From: [REDACTED]
Sent: 17 November 2022 12:46
To: Planning
Subject: Planning application 3/2022/1039 Land adjacent to 115 Kemple View

I have received your letter dated 14/11/2022 regarding this re-submission.

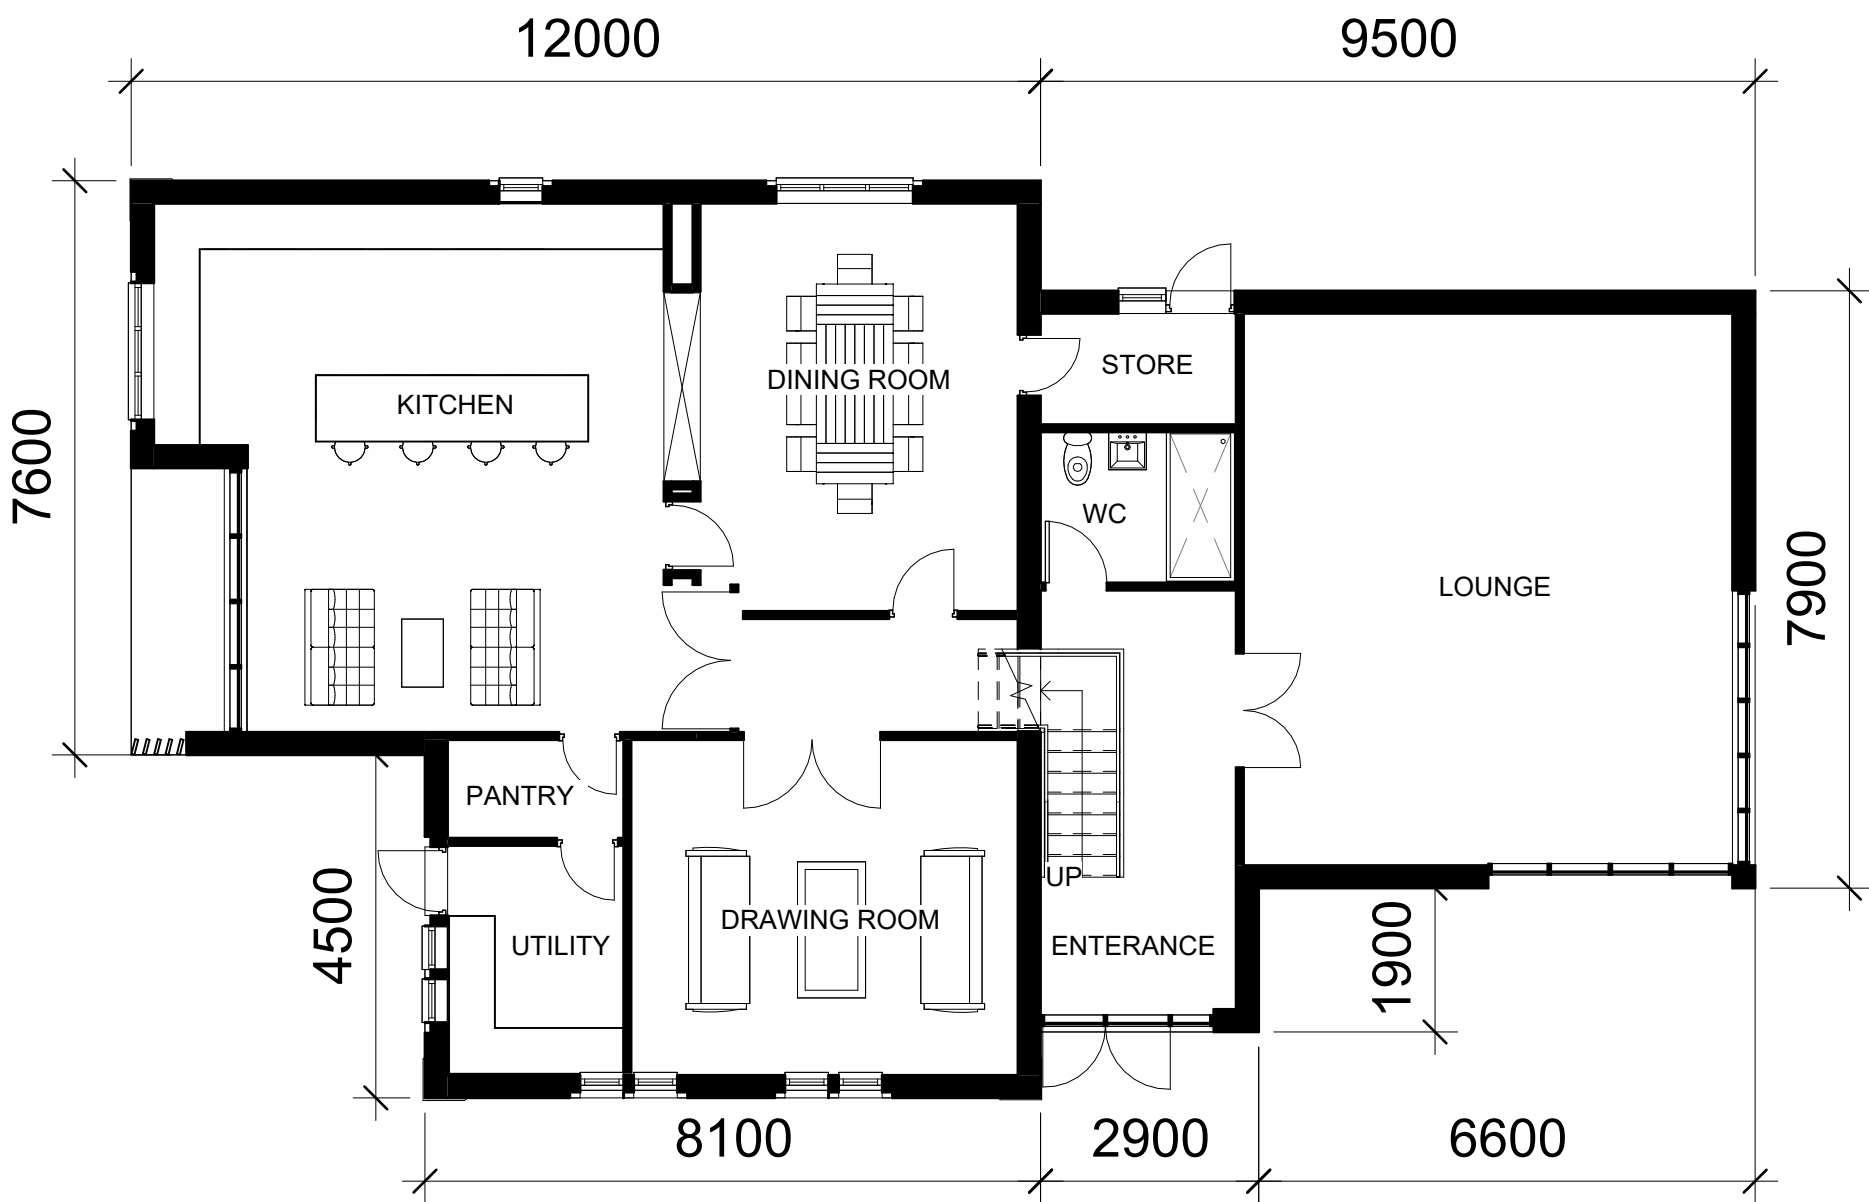
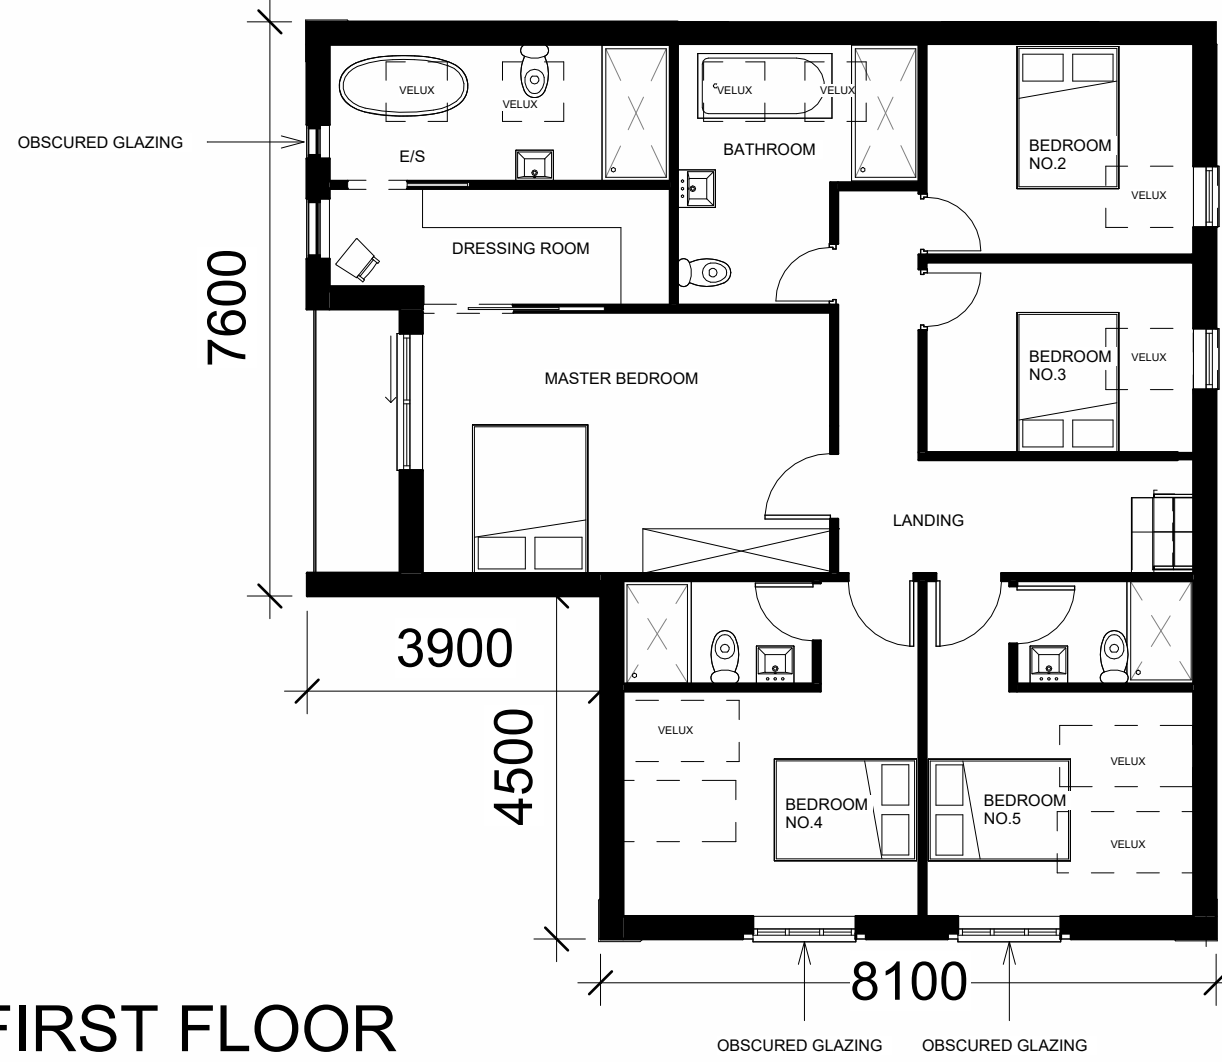
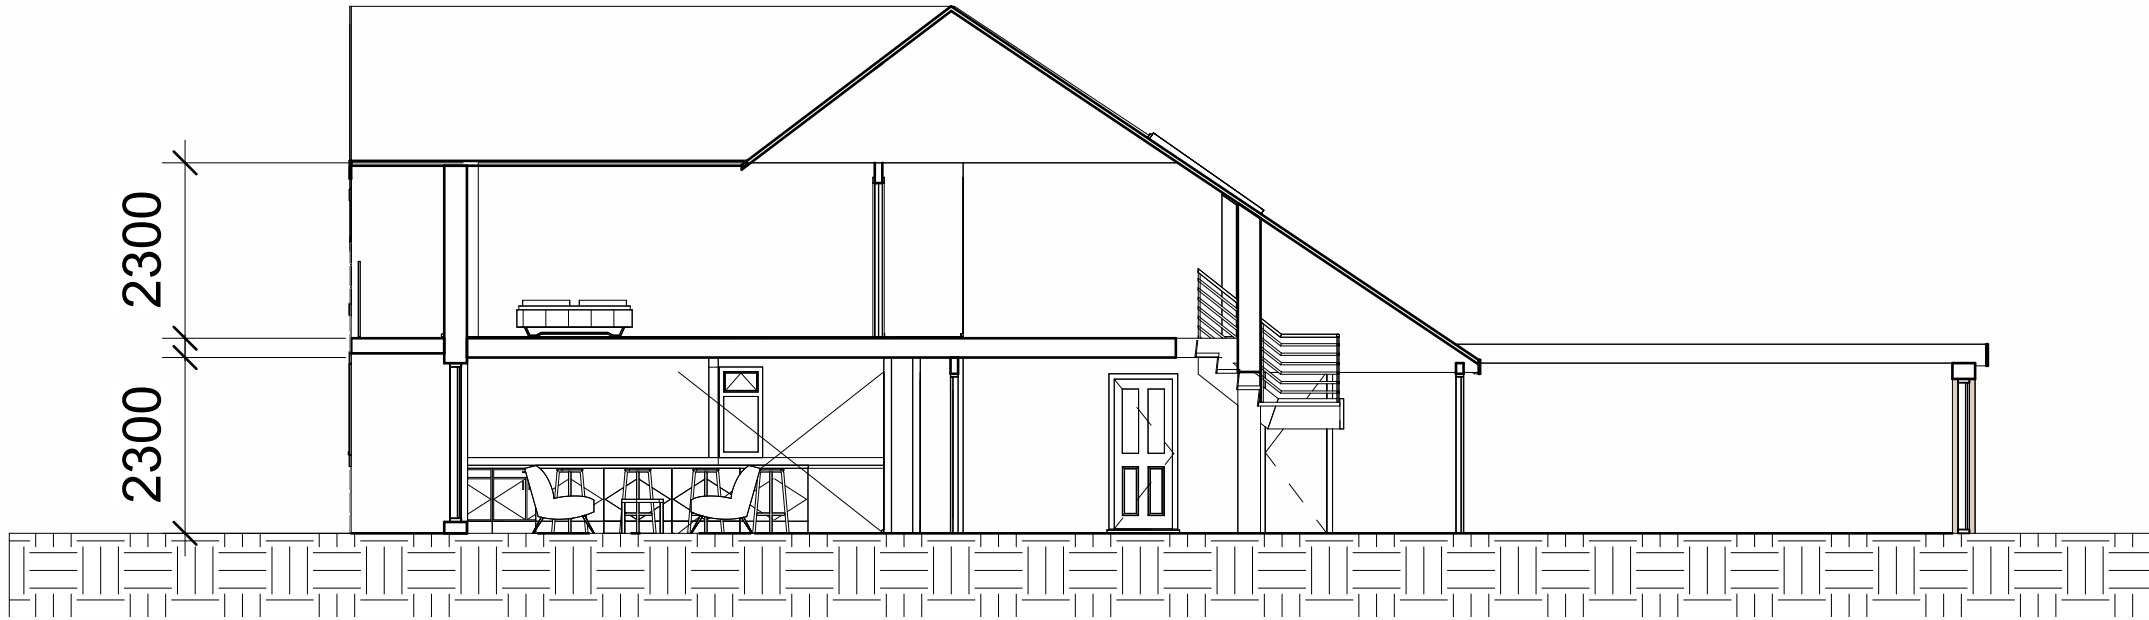
[REDACTED]
[REDACTED] and the first-floor windows on the Proposed North West Elevation of Building 2 will [REDACTED]

[REDACTED] Not only that but there is also a balcony proposed at first-floor height to encourage this!!!! The 'turning head' is [REDACTED] I really don't know how [REDACTED] acceptable.

Looking at the plan of the Building 2 I see that the two windows on the left of the NW facade belong to a dressing area and bathroom so there is no reason that they cannot be made high level and obscured with Velux in the roof if extra light is needed (as it would appear the bathroom area already has).

The adjoining master bedroom shows double patio doors leading onto a balcony. This is the area where people [REDACTED]

[REDACTED] so why not amend the plan and turn the patio doors and balcony 90 degrees anti-clockwise to look towards Building 1 instead? This would involve changing the roofline slightly to incorporate a dormer but who ever uses patio doors onto a balcony in a bedroom, especially one that don't get any sunlight as it is NW facing. So why not just incorporate a dormer window on the SW elevation with Velux in the roof for extra light if needed?
